# OBJECTION

**Application Reference 6/2021/2752/VAR**  
**Variation of Condition 18 (revised layout) on planning permission 6/2019/2752/VAR**

Drawing Title  
Proposed Elevations 2 of 2

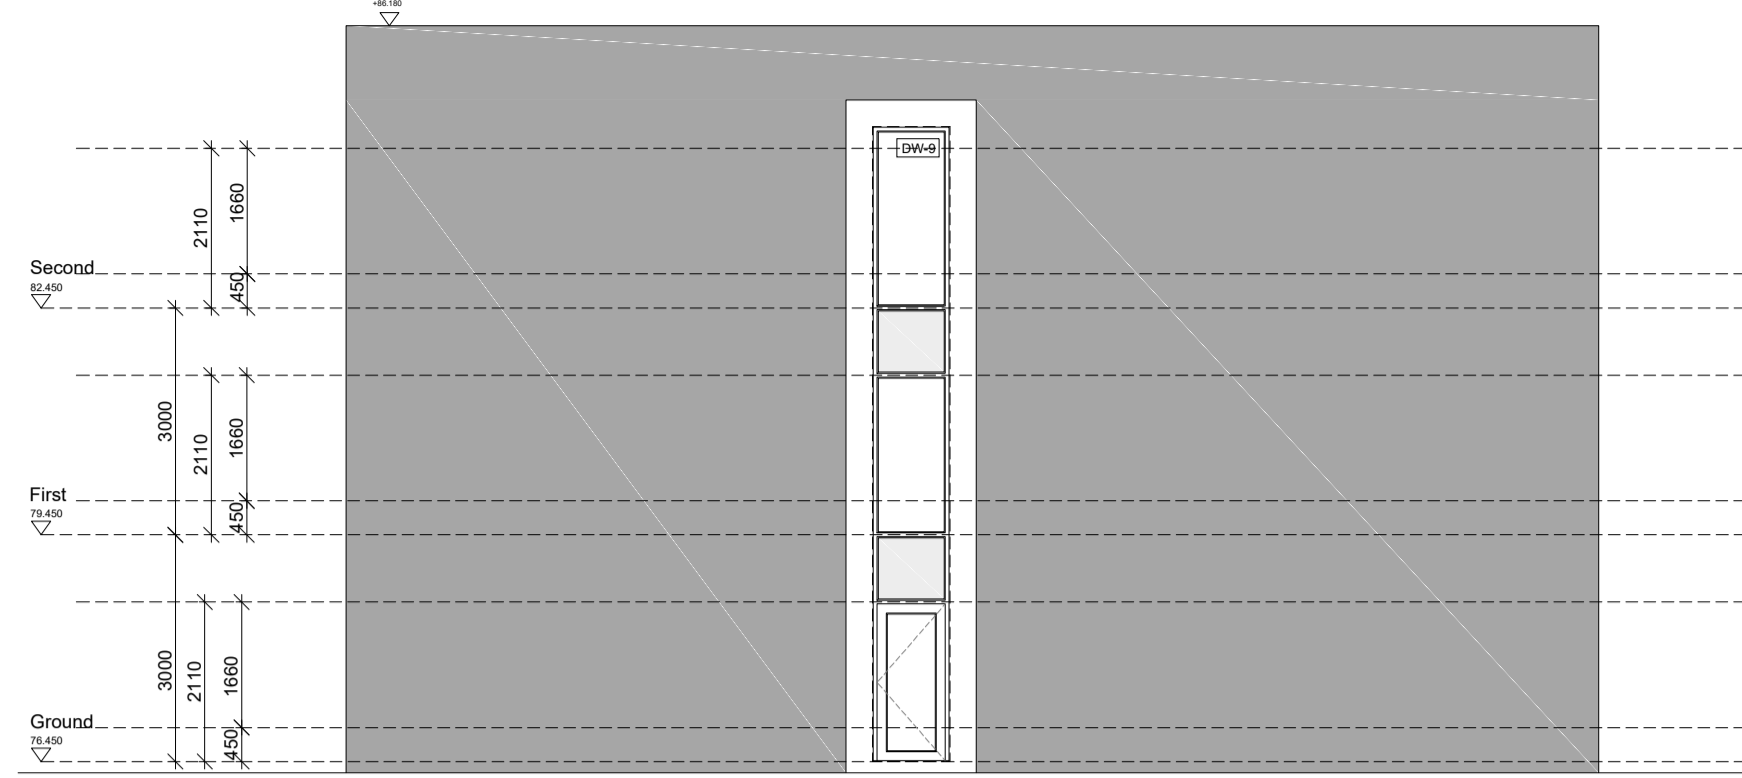
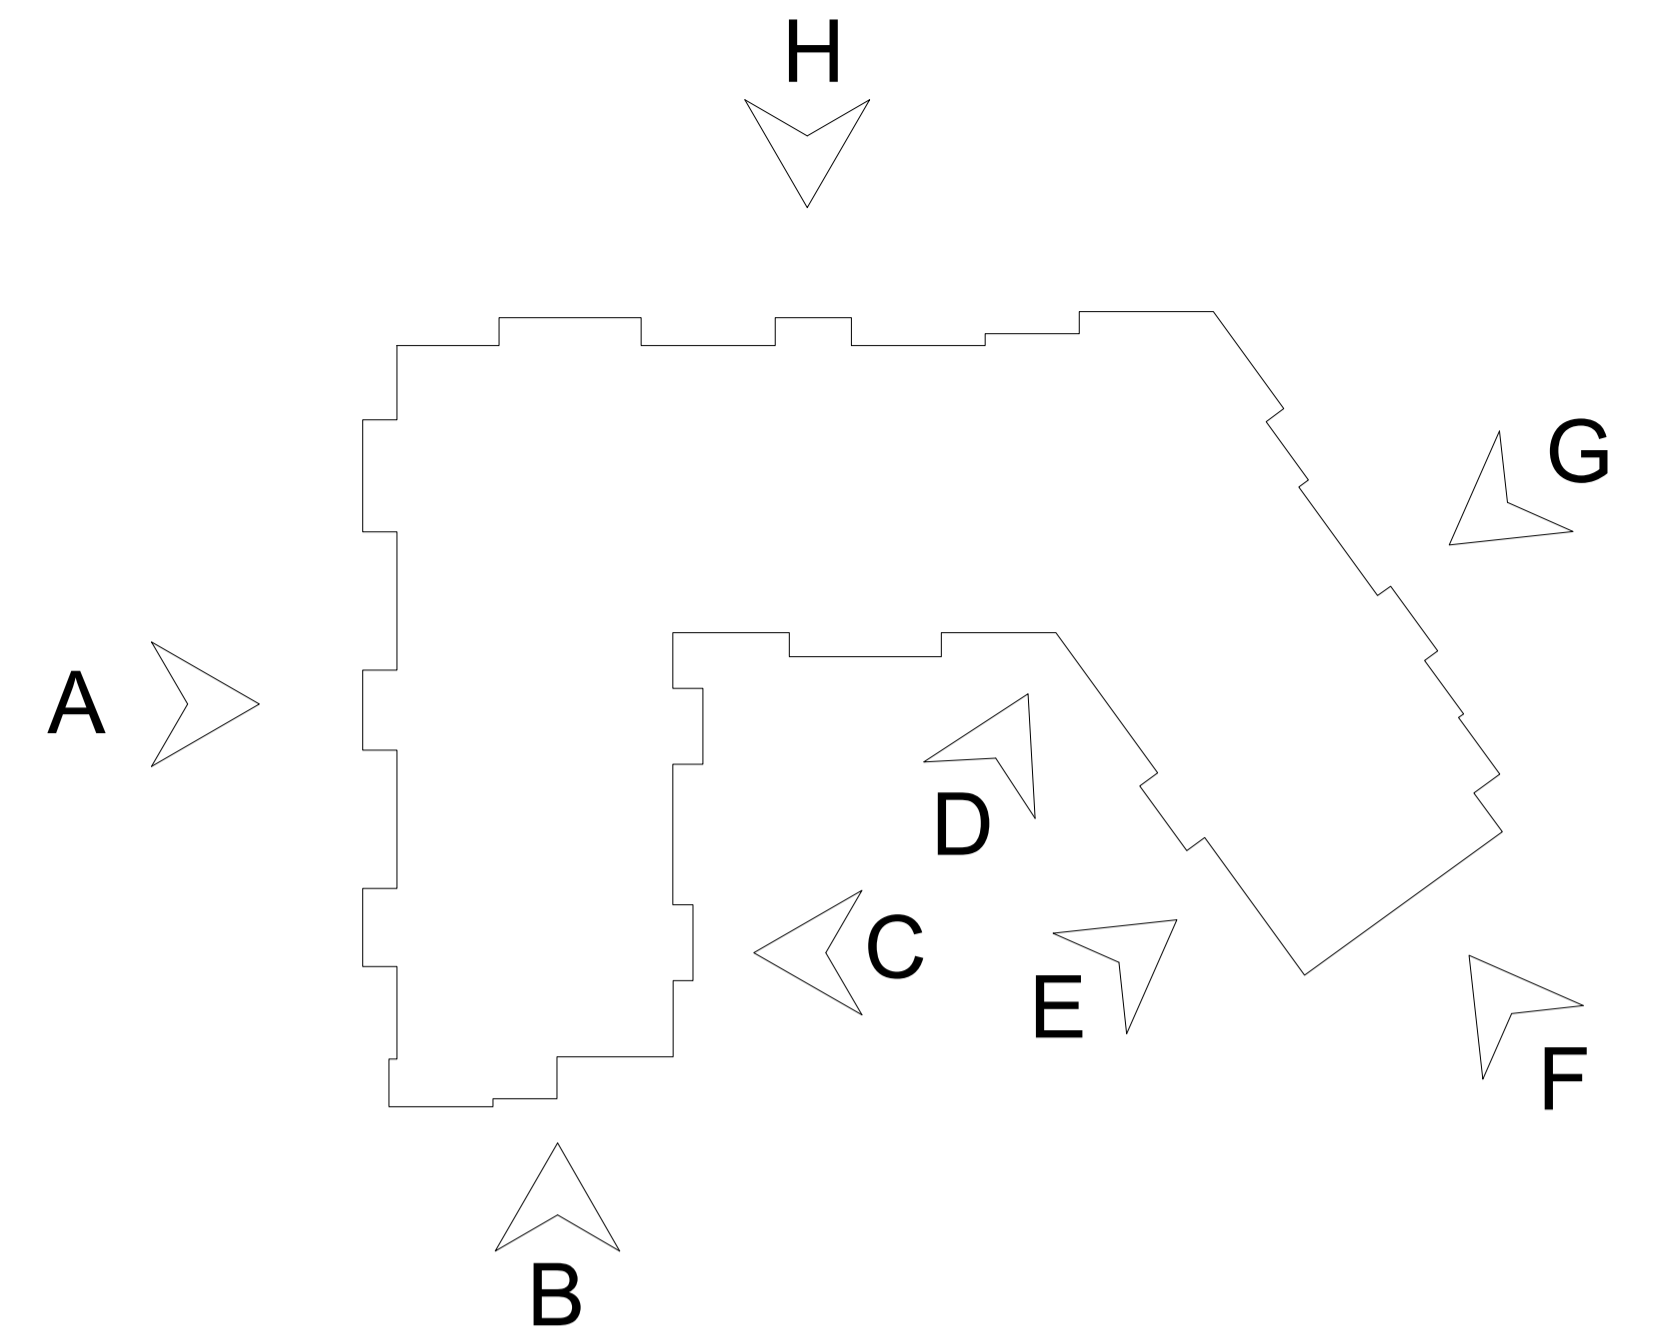
- **Plant Room on North Elevation facing Manor Road**
- **Main Kitchen on first floor North Elevation facing Manor Road**
- **Laundry Room on Ground Floor North Elevation facing Manor Road**
- **Removal of balconies from North Elevation**
